OUTLOOK POWERS & GRINNELL

DEVELOPMENT PLAN

EL PASO COUNTY, COLORADO
SITE DEVELOPMENT PLAN

V1_Site Development Plan Redlines.pdf Markup Summary

GRADING PLAN

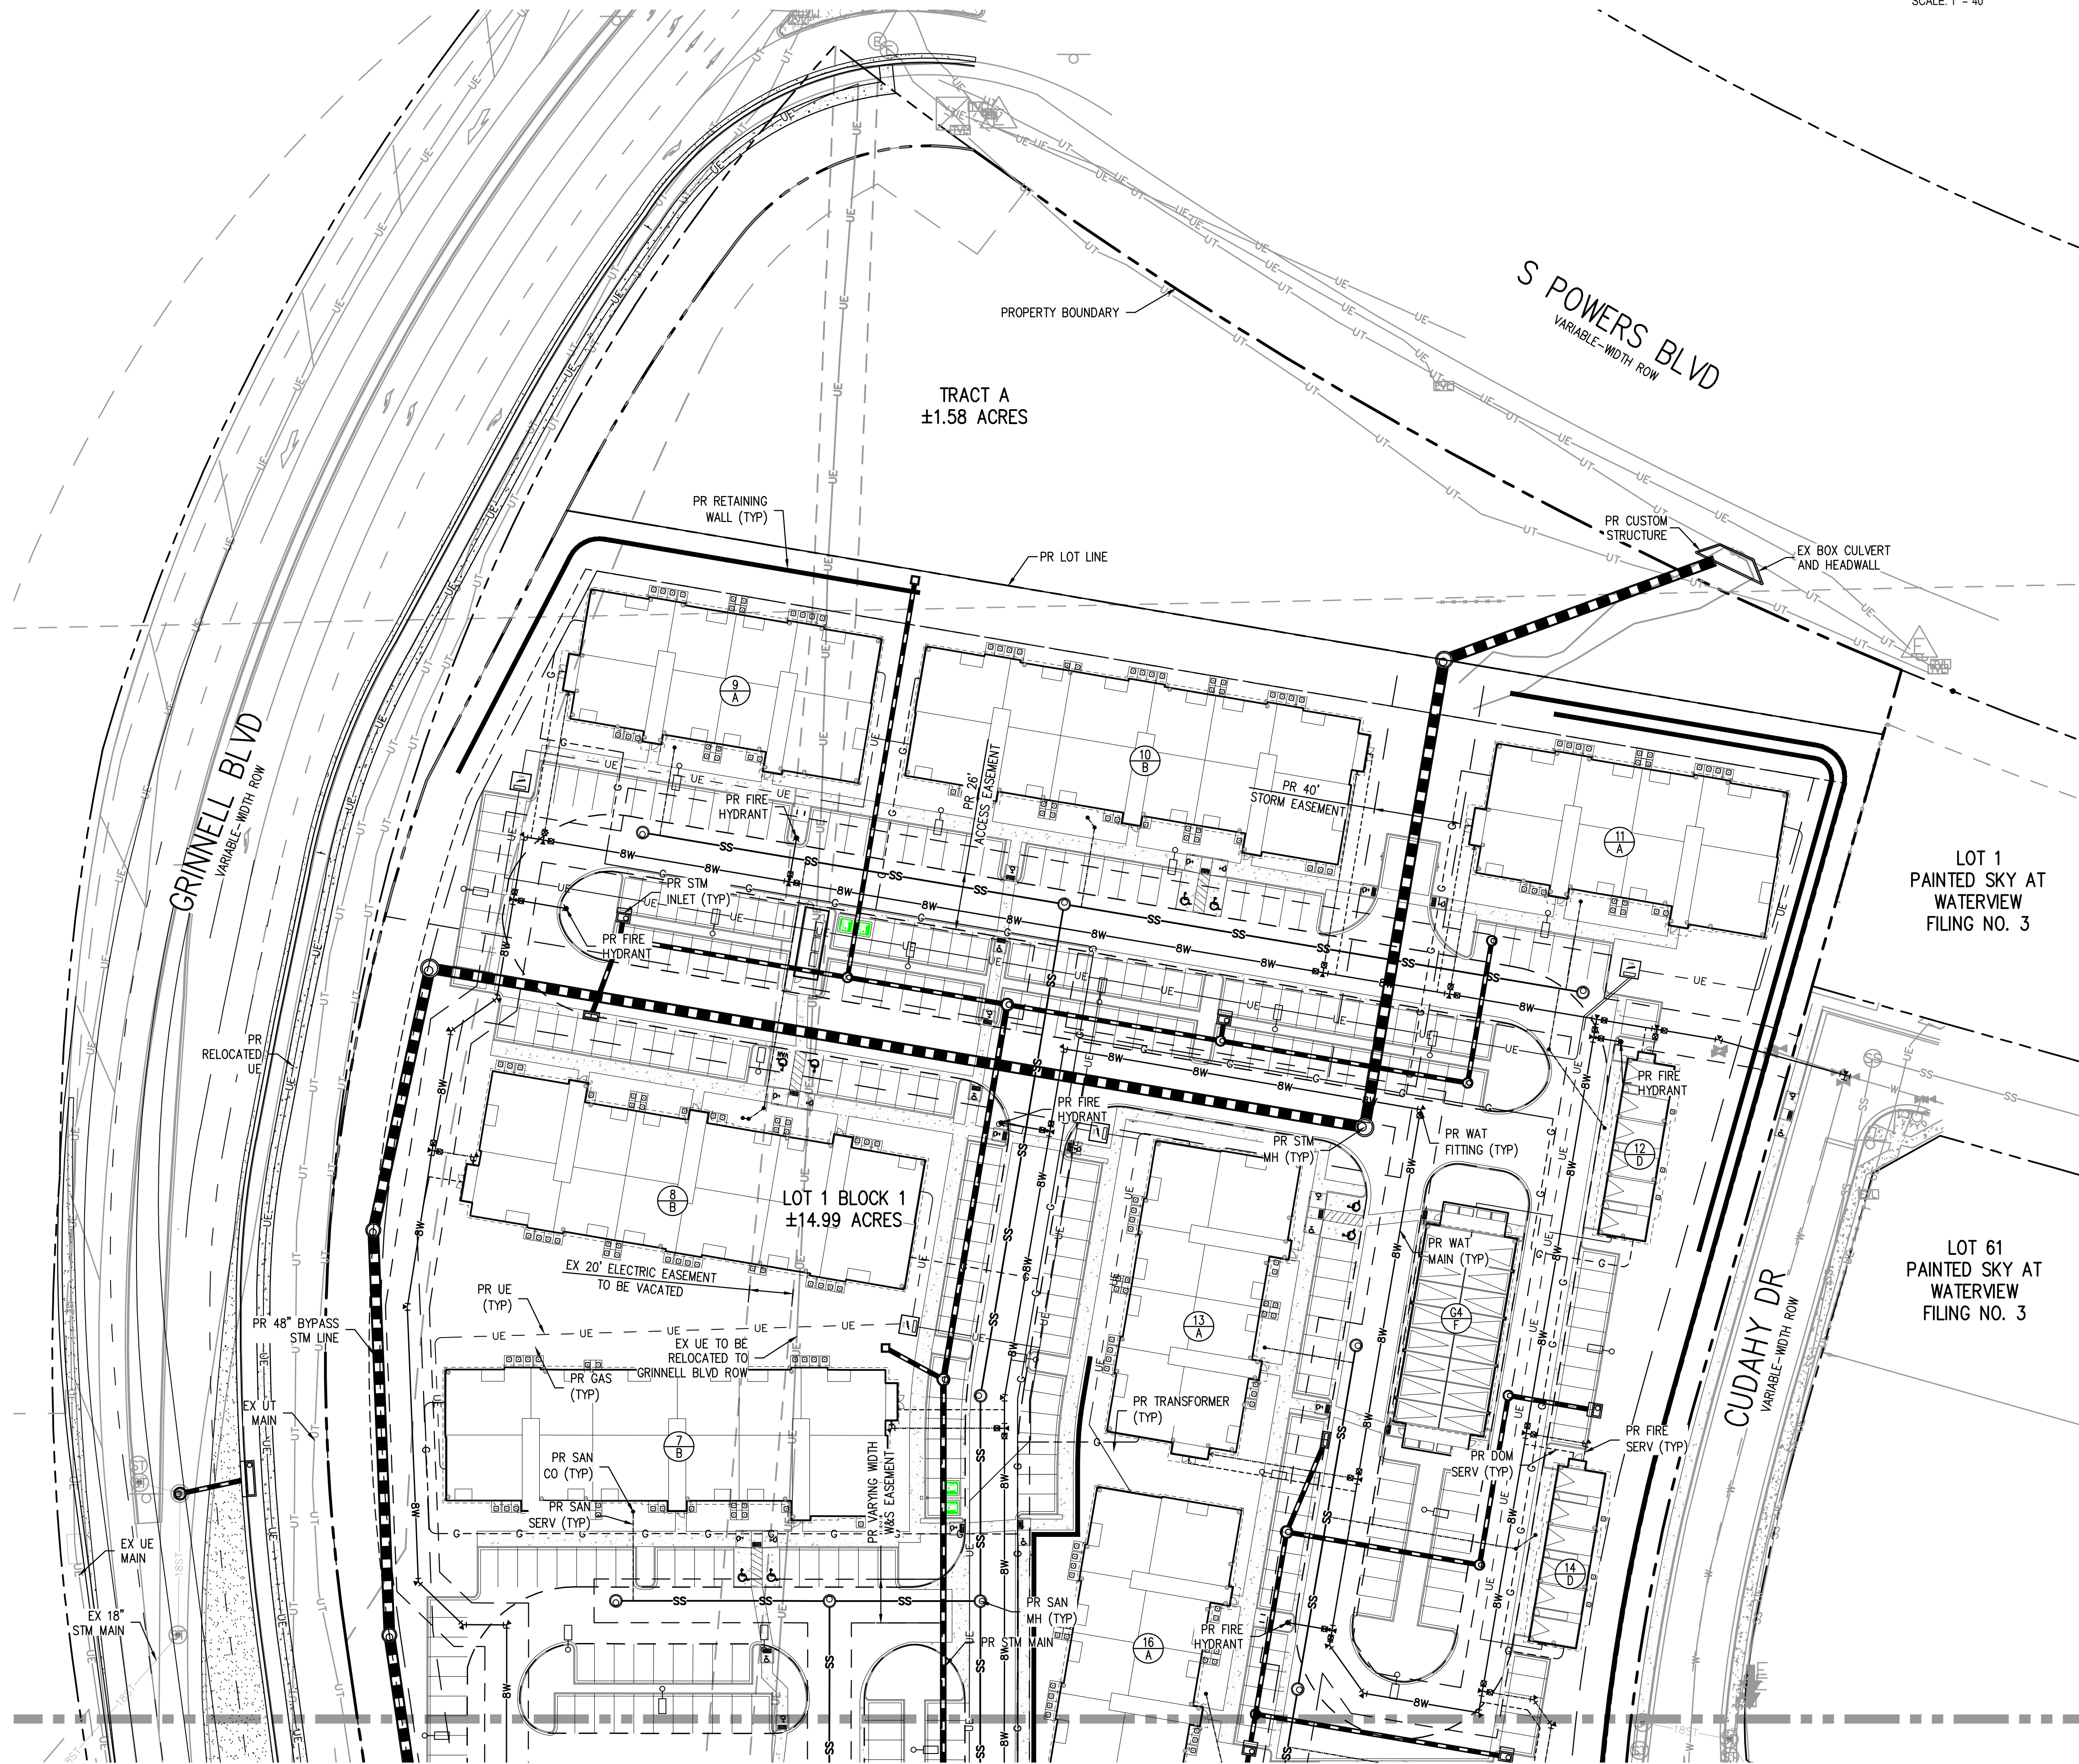
See comments on CD set in SF2318 in regards to grading for sidewalks and retaining walls.

Show crossspan

MATCH LINE - SEE SHEET 5

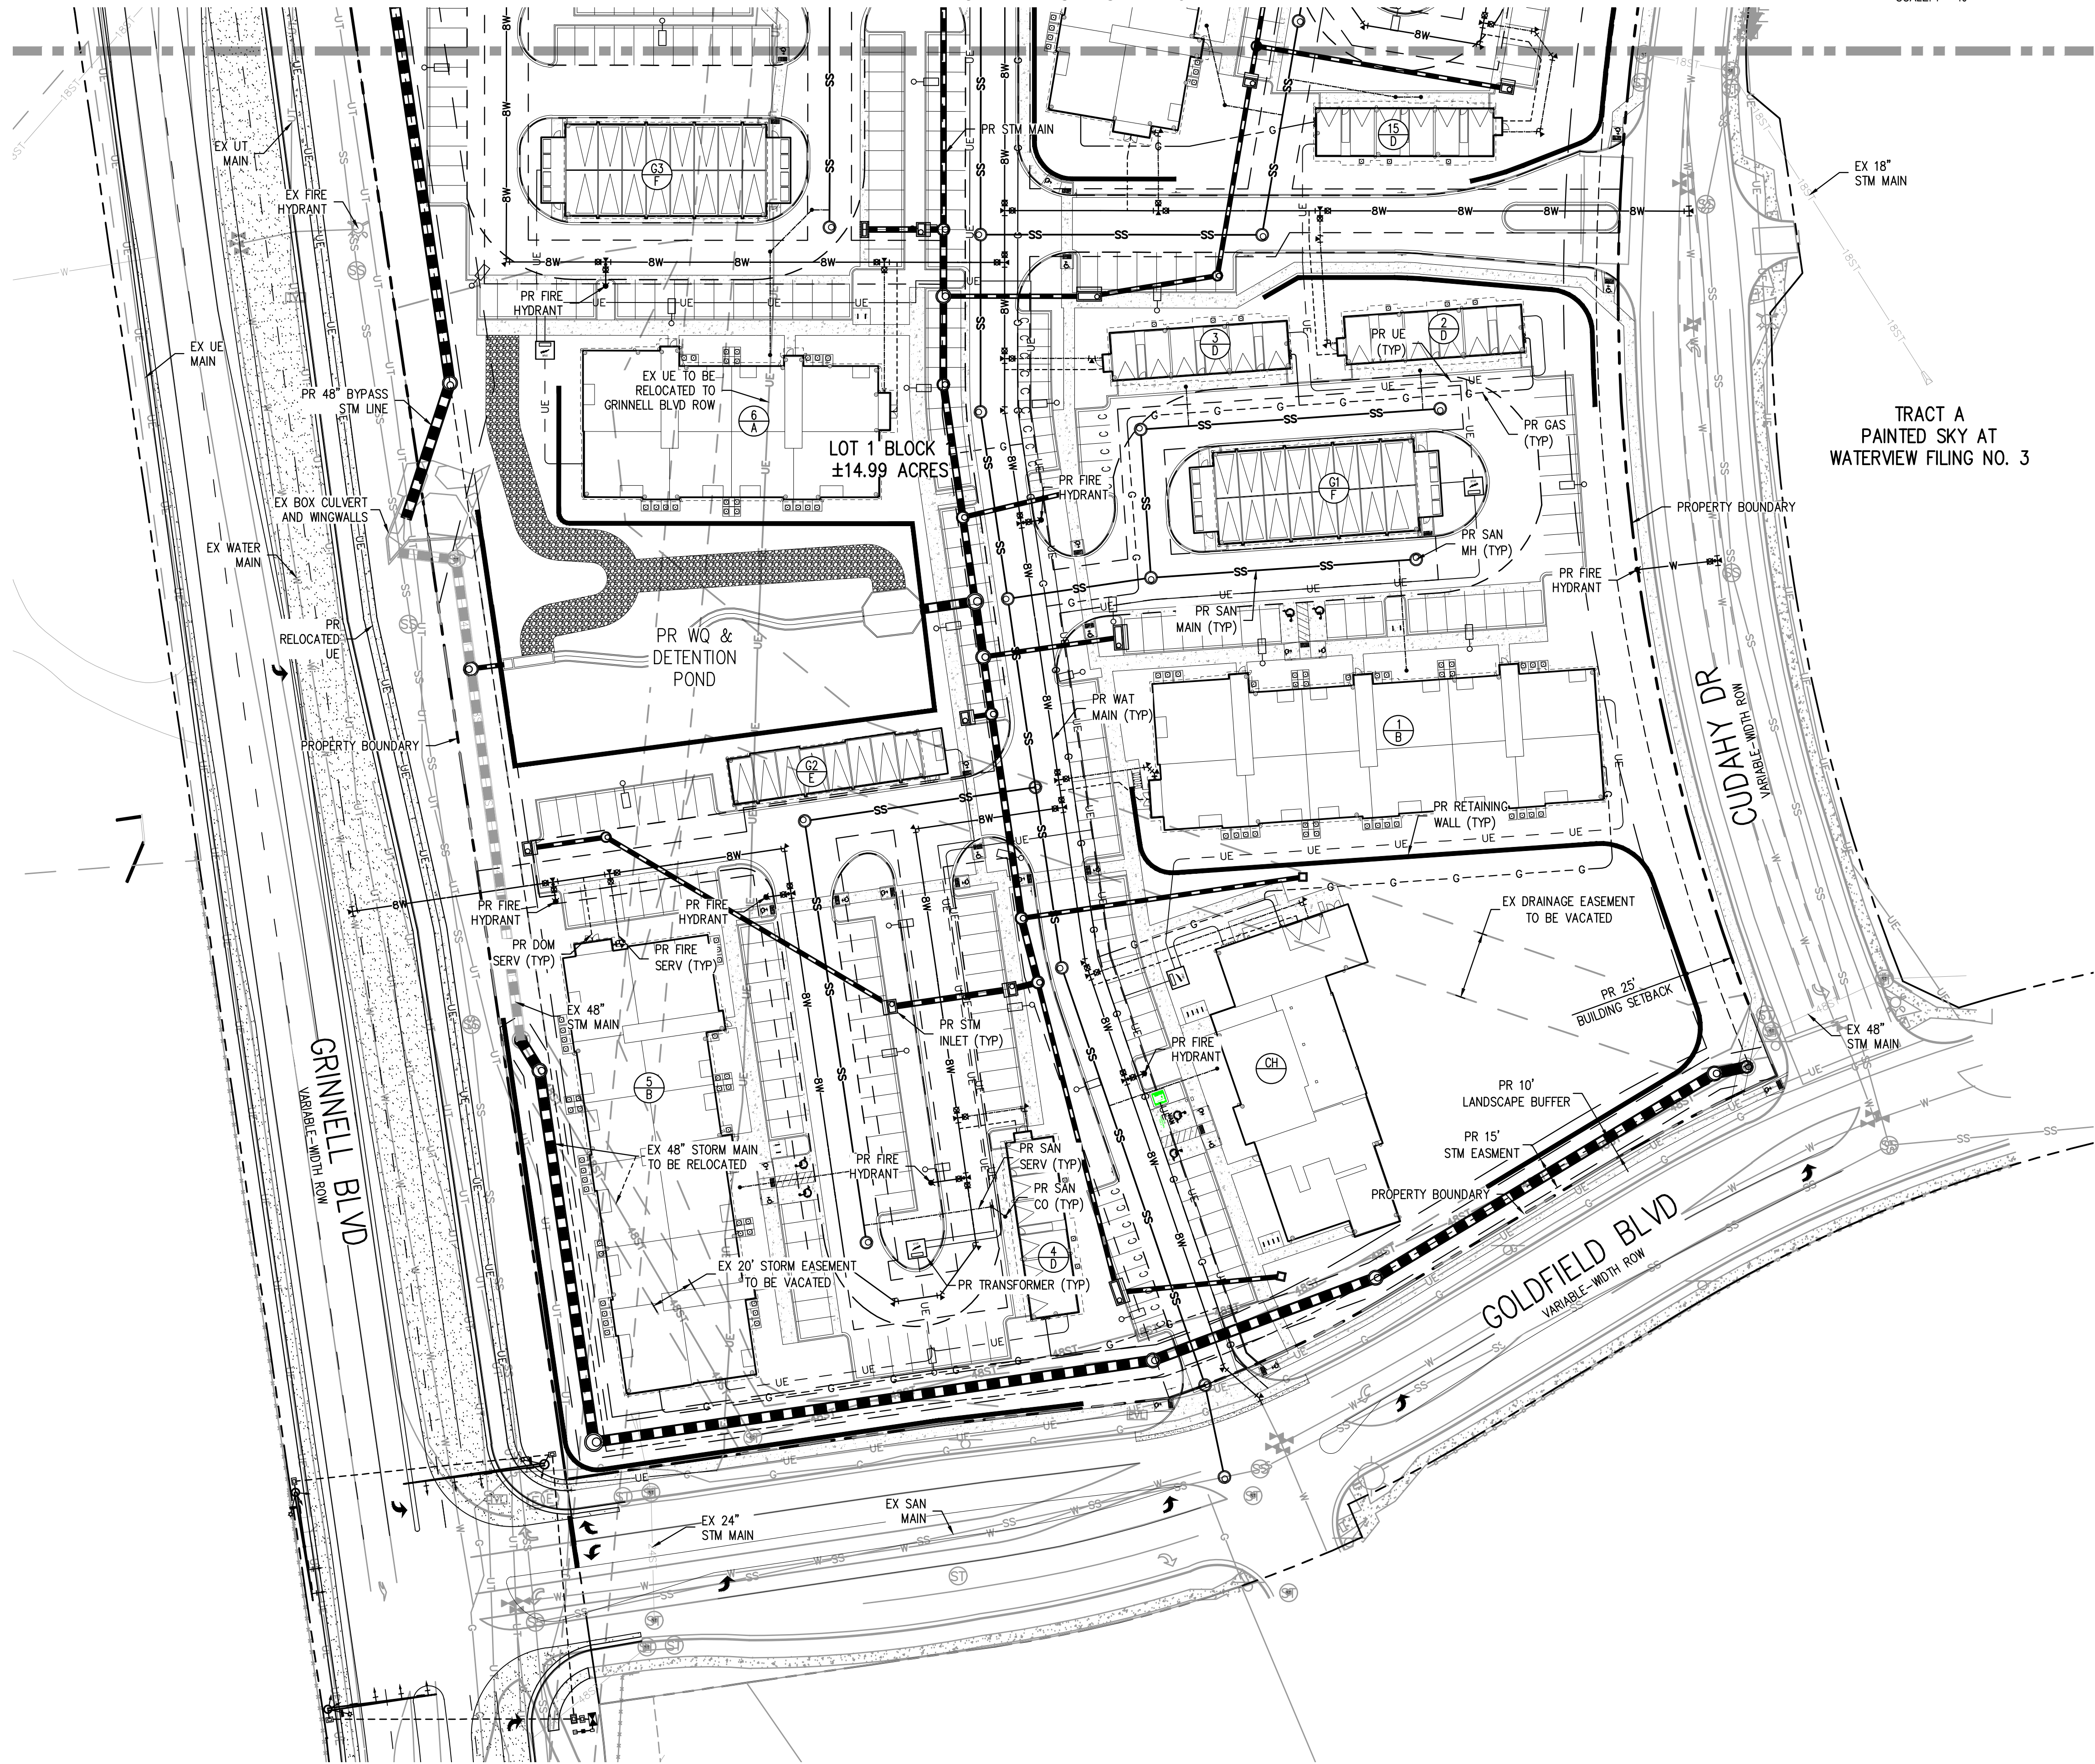
Label or remove
